An Bord Pleanála Oral Hearing : ABP-314724-22

**Railway (MetroLink – Estuary to Charlemont via Dublin Airport) Order
Application**

Submission by

Michael Boyle, B.E.(Chem), MIE

Charlemont LUAS stairs & lift connection 2024

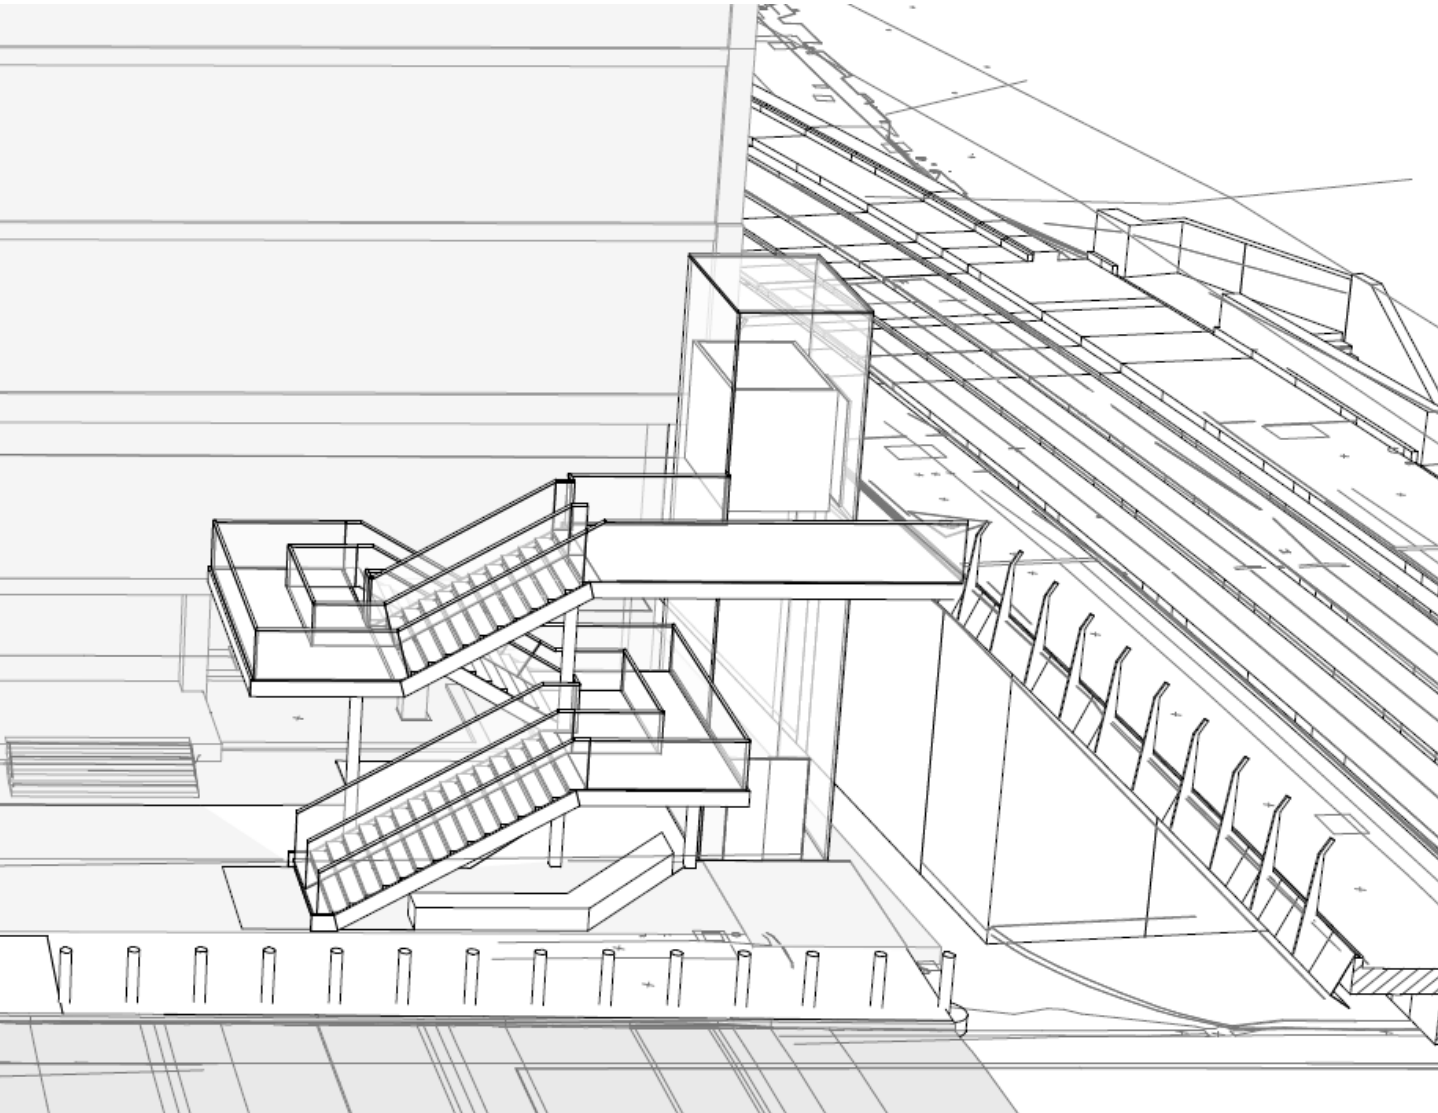
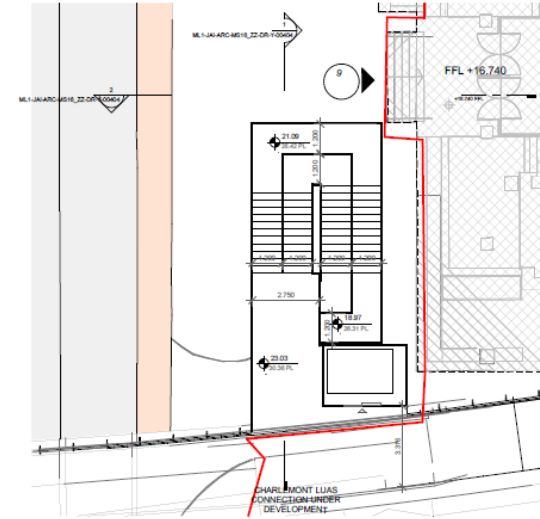
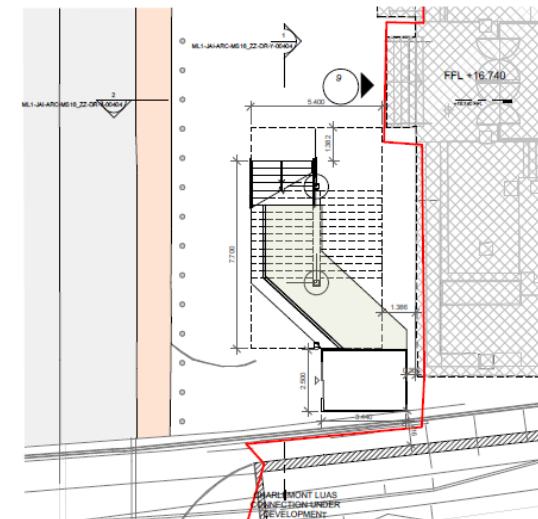
Charlemont is not an ideal place for an interchange. The existing access to the Luas is a climb up and down two winding metal staircases, one either side of the canal, clearly not intended to cater for large volumes of passengers changing lines. The stairs at the south end of the Luas and the lift to/from the Luas elevated platform connect with the footpath of Grand Parade, a busy street.

The design for the proposed MetroLink Station provides passenger exit/entrances at both ends : Grand Parade and Dartmouth Road. For passengers switching lines, the walk along Grand Parade would be about 80 metres, on a narrow footpath right beside a busy road, a hazard for walkers in both directions, particularly those with luggage, as well as presenting difficulties for wheelchairs.

During the course of the Oral Hearing, it was suggested that a lift down to the MetroLink platform should be provided, with a short lay-by on Grand Parade to allow wheelchair passengers to alight. Space for a lay-by is limited.

Consideration should be given to deferring construction of the Charlemont Station until there is enough demand to proceed with connecting the southern section of the Luas Line to the MetroLink line.

Switching facilities at Charlemont should then be substantially upgraded.
